CITY OF PORTLAND, MAINE

PLANNING BOARD

May 20th, 2013

Project Name: **Commercial Development including gas station and convenience store with ATM**
Project ID: 2013-086 CBL: 237-A-012
Address: 2282 Congress Street, Portland
Joint Applicants: C J Developers, Inc. and Portland Property Holdings, LLC
Planner: Jean Fraser

SHEET TITLE  
**GENERAL IMPROVEMENTS  
PLAN AND PROFILE**

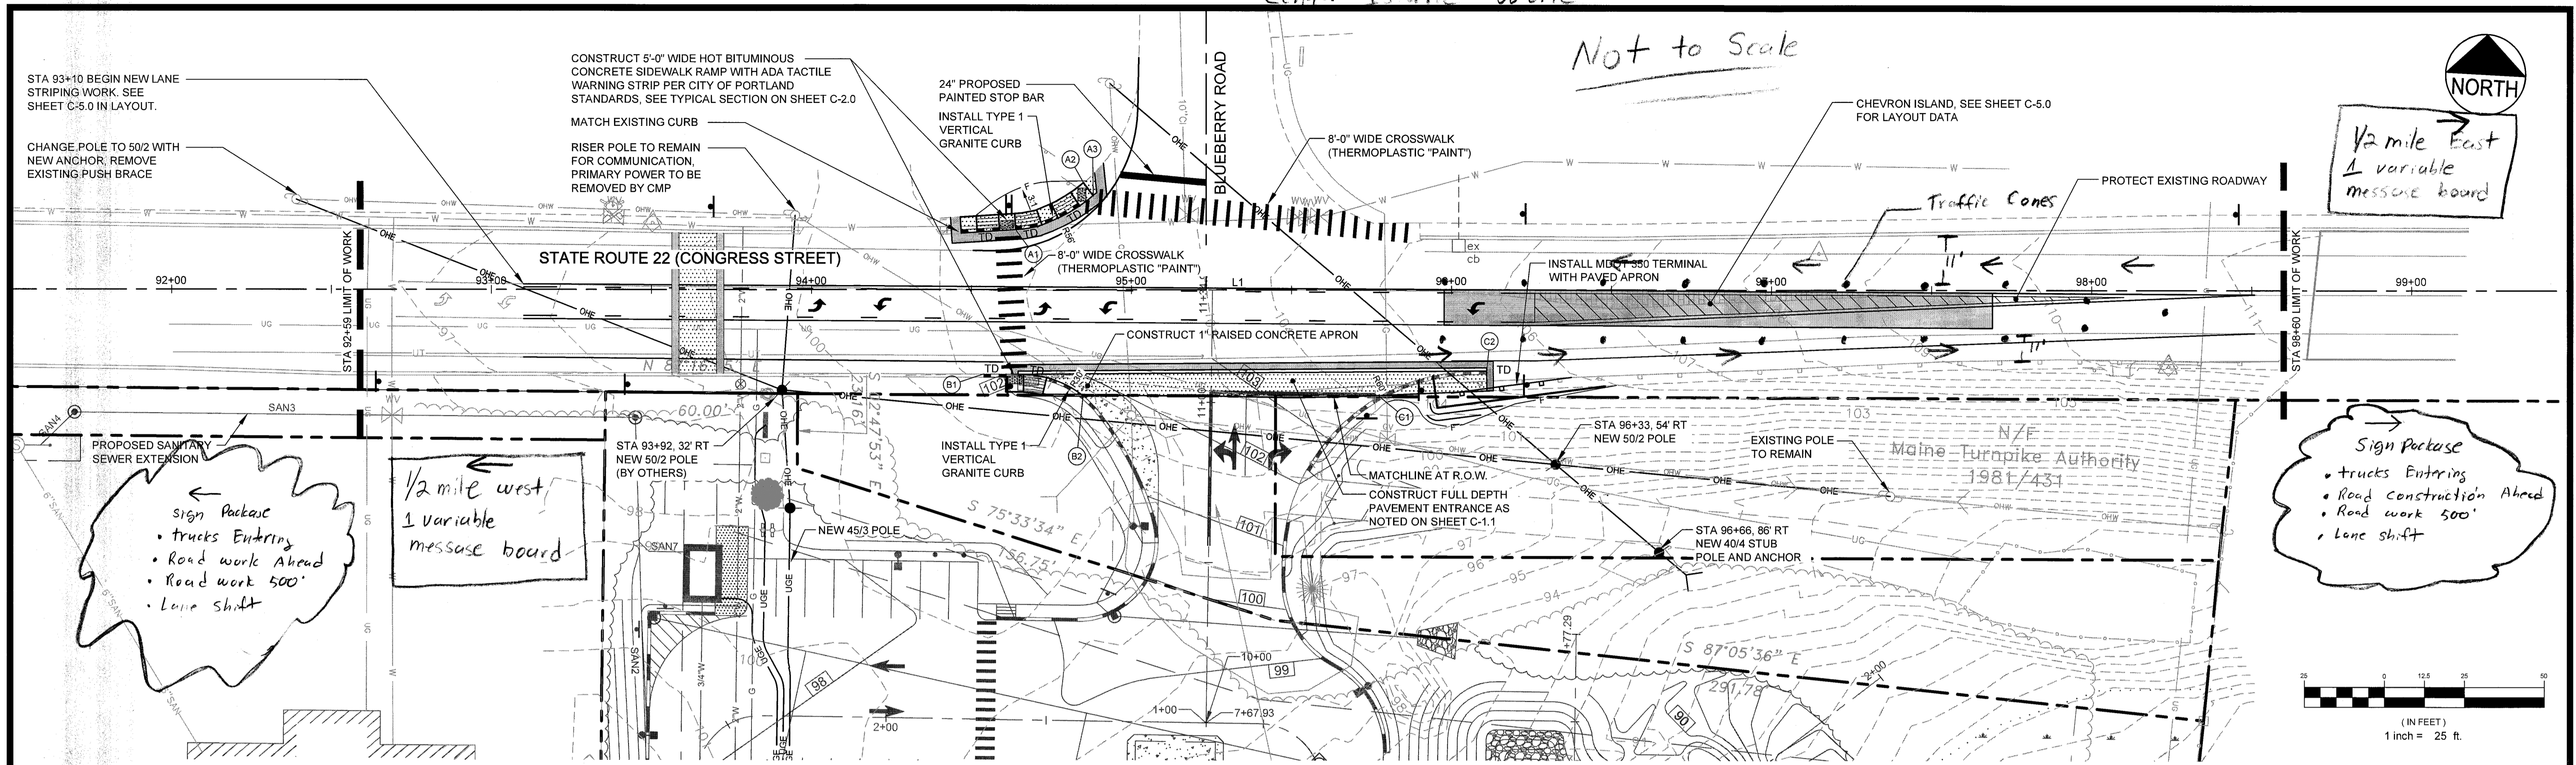
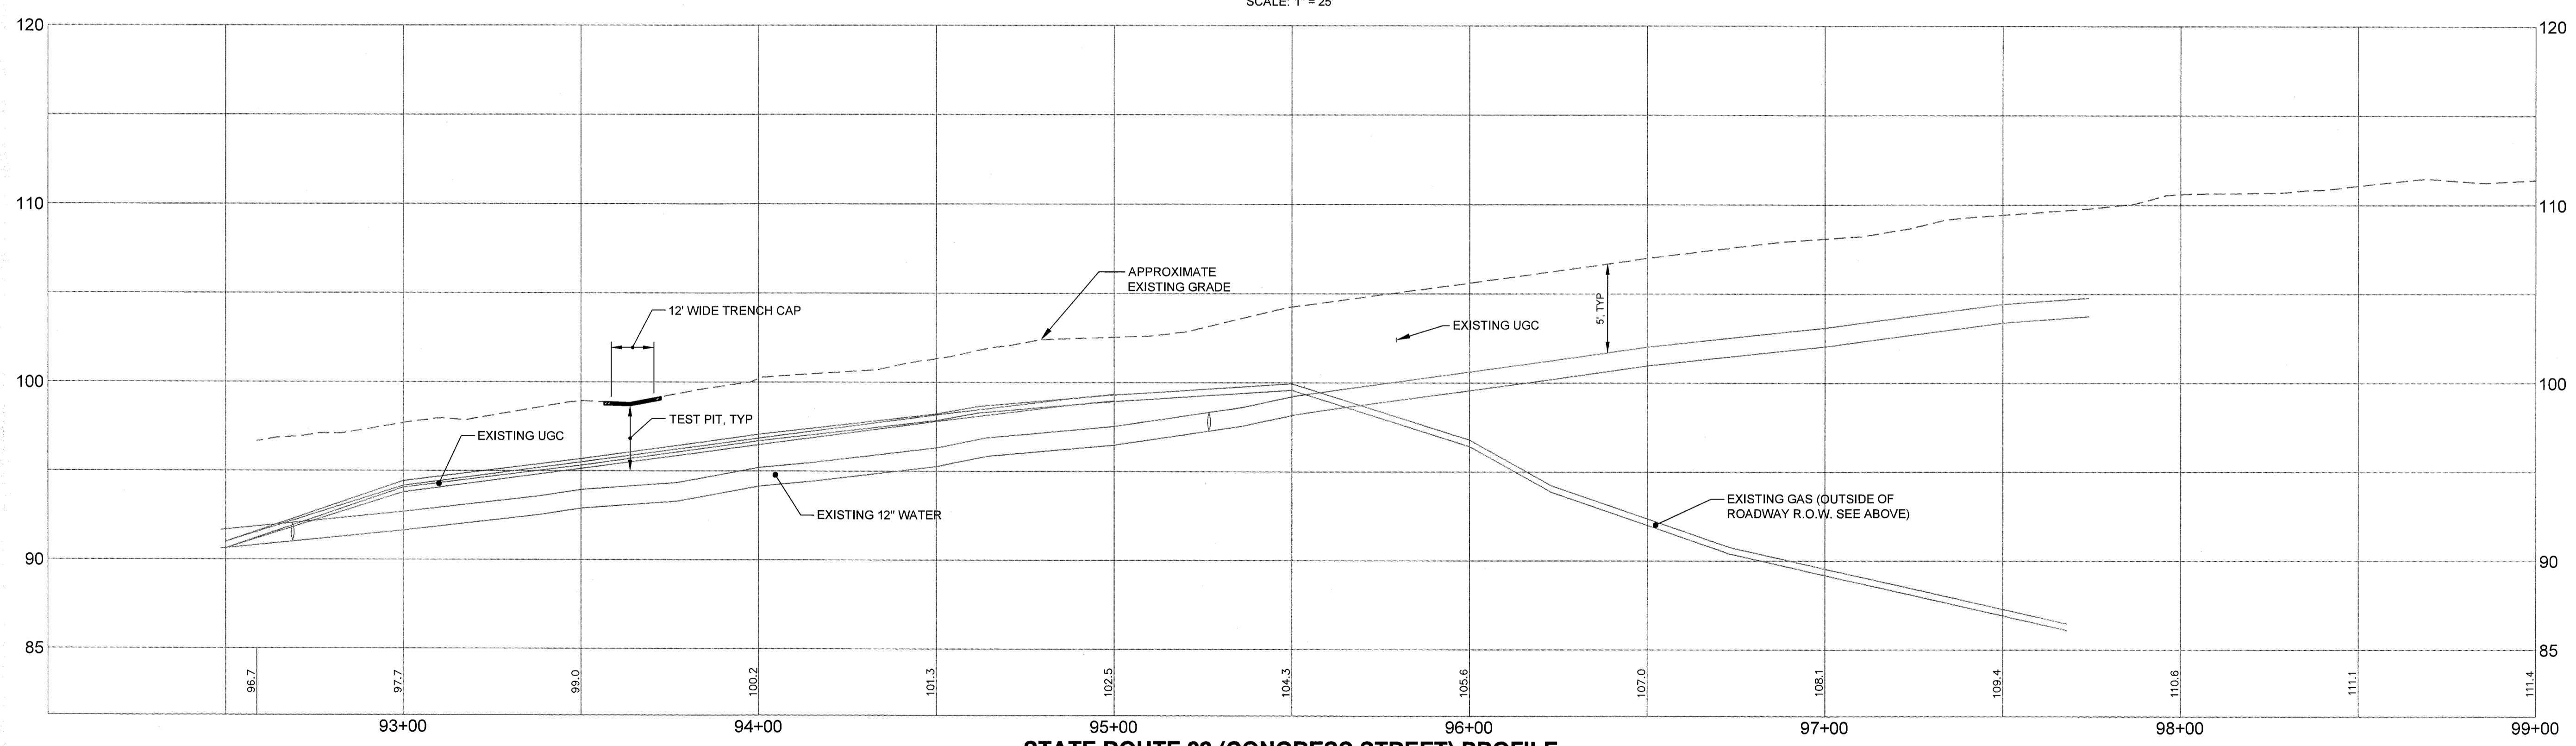
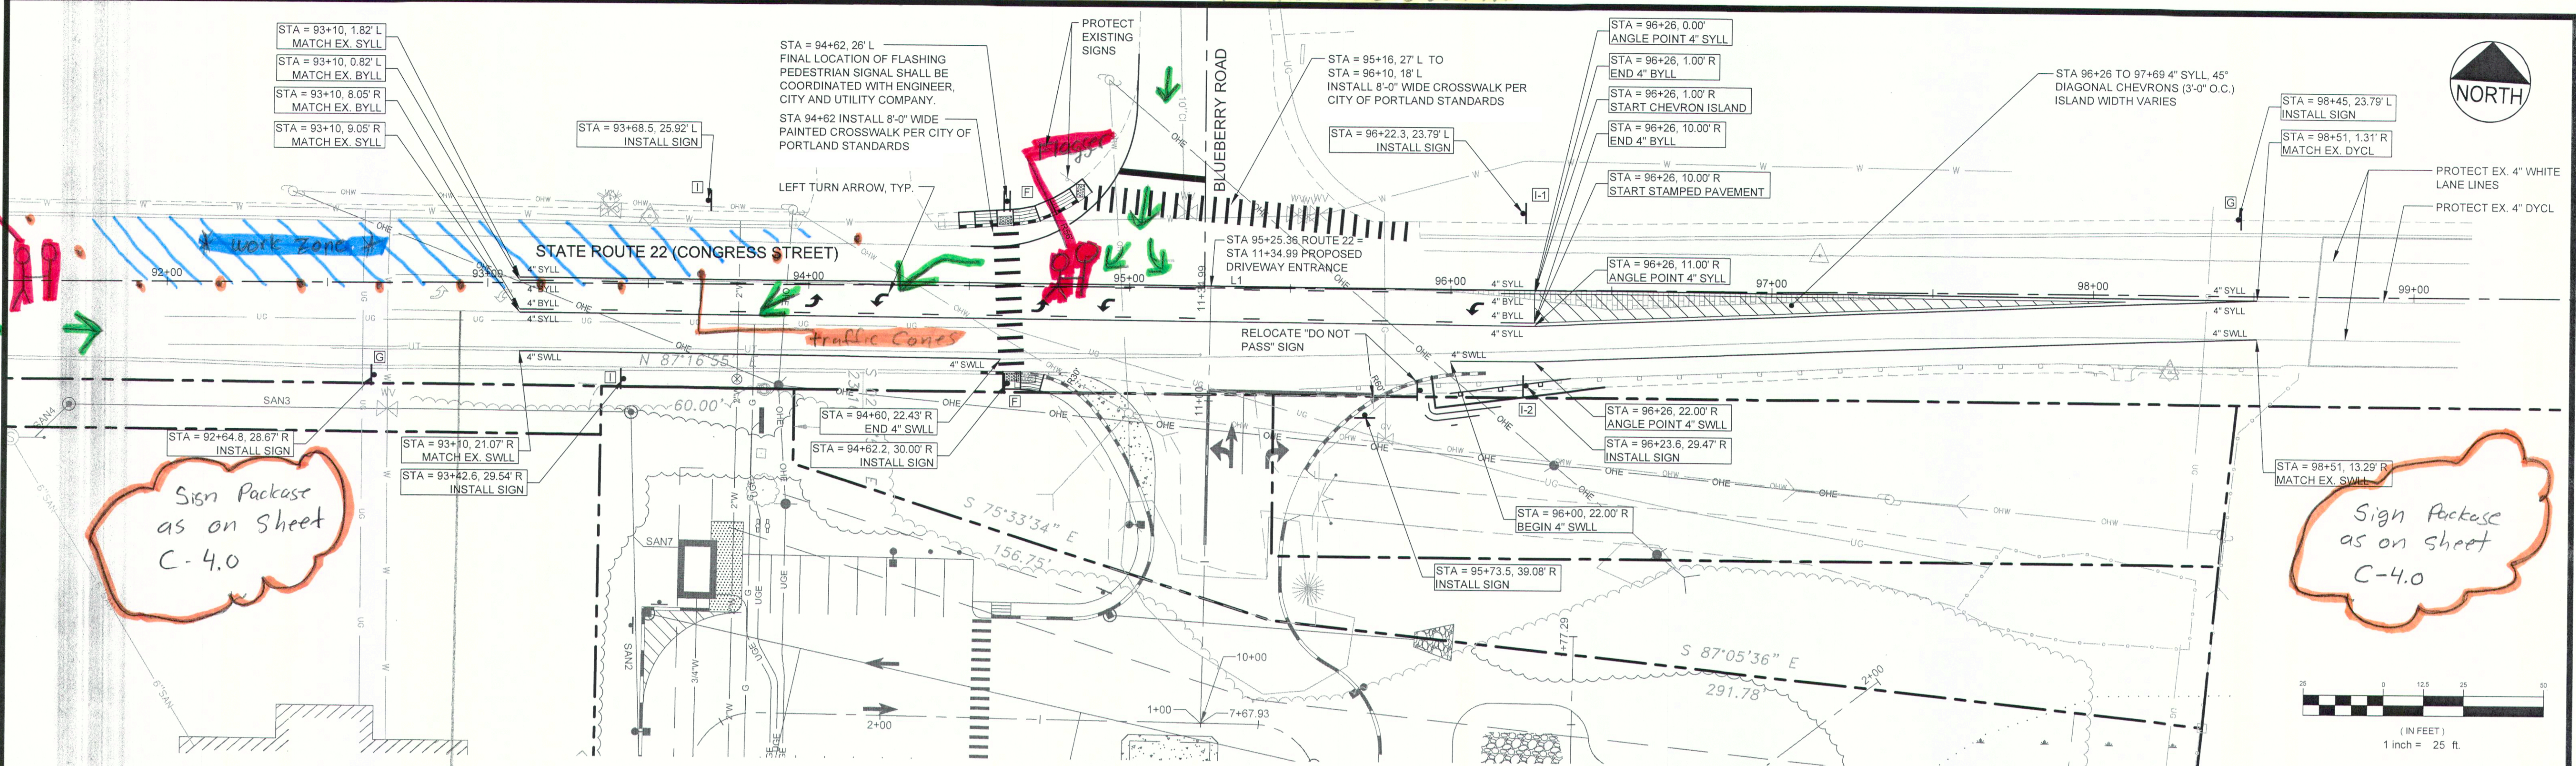
- The applicant has developed an improvement plan for Congress Street such that left-turn accommodations are provided. I support the general concept of the plan provided in the application. Final design plans shall be submitted to the City for review and approval (It should be noted that adjustments to the design may be required during this review process).

- A pedestrian crosswalk is being proposed on Congress Street between the project site and Blueberry Road. Through the contract rezone process the crosswalk was to include a refuge median island in addition to a flashing sign warning system. Given vehicle turning needs, a refuge island is not feasible at this location. In lieu of the refuge island the applicant shall construction an ADA accessible landing on the northwest radius of Blueberry Road. In addition, the crosswalk pavement marking shall consist of durable paint. Final design elements shall be reviewed and approved by the City.

- Per City standards the applicant is required to construct a sidewalk along their property frontage (60 feet of frontage). The project does not meet sidewalk waiver requirements. In lieu of constructing the required sidewalk, the applicant shall install a painted crosswalk on the Blueberry Road approach to Congress Street.

SHEET TITLE: SITE LAYOUT PLAN

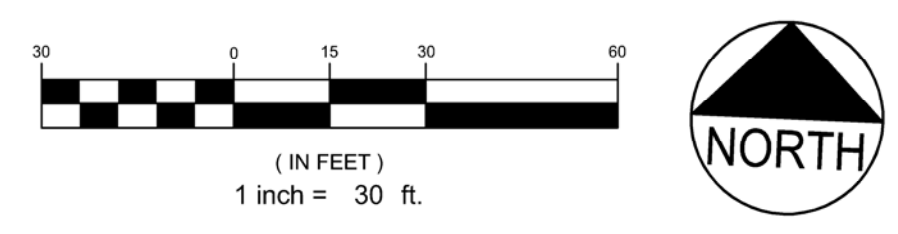
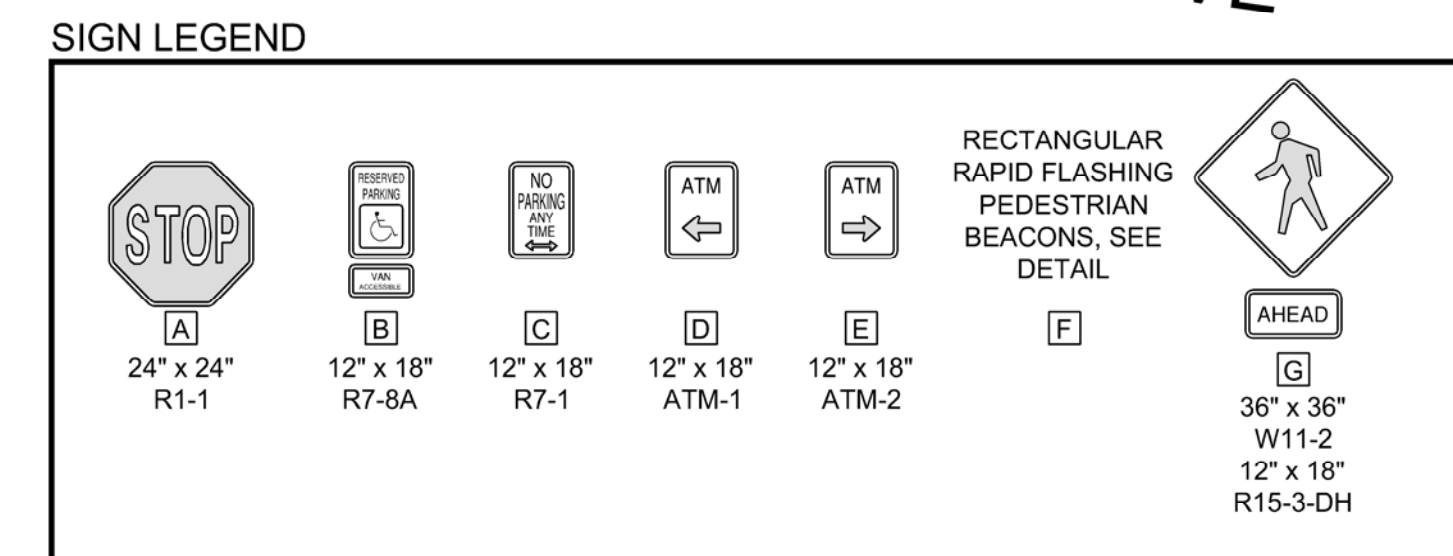
- It is suggested that the pedestrian facility between Congress Street and the proposed convenience store building be as direct as possible. This may require the loss of some of the 9 parking spaces located along the front of the property.
Status: The applicant has revised the site plan to improve the crosswalk alignment and given constraints with Maine Turnpike Authority property, I find the proposed condition to be acceptable.

- Parking supply seems excessive for the type and scale of the proposed land use. Supporting documentation on the parking needs shall be provided.
Status: The applicant has revised the site plan and is now proposing to construct 26 parking spaces with an option for future expansion of the parking supply if deemed necessary. I find the proposed condition to be acceptable.

- Auto-turn analyses shall be provided that supports on-site circulation aisle widths and the width of the driveway entrance on Congress Street. The applicant should also provide information on the number of large trucks anticipated to enter and exit the site.
Status: The site plan has been revised based upon discussions with the applicant and I find the proposed plan to be acceptable. I would note that the applicant did add a raised concrete apron at the driveway entrance and I find this condition to be acceptable. A waiver for driveway width is required and given large truck turning requirements, I support a waiver from City standards.

- It is unclear whether there are vehicle circulation restrictions on site (e.g. one-way vs. two-way). Signage and pavements markings shall clearly support proposed circulation restrictions.
Status: It is my understanding that the revised site plan accounts for a one-way circulation around the back side of the convenience store. Signage and pavement markings should be provided.

- Many aisle widths exceed City standards and waivers from our technical standards may be necessary. As noted above, supporting information will be required before I render any decision on waivers.
Status: Given the specific needs of on-site vehicle circulation and accessibility to fueling areas, I find the proposed layout to be acceptable and support waivers from City standards.
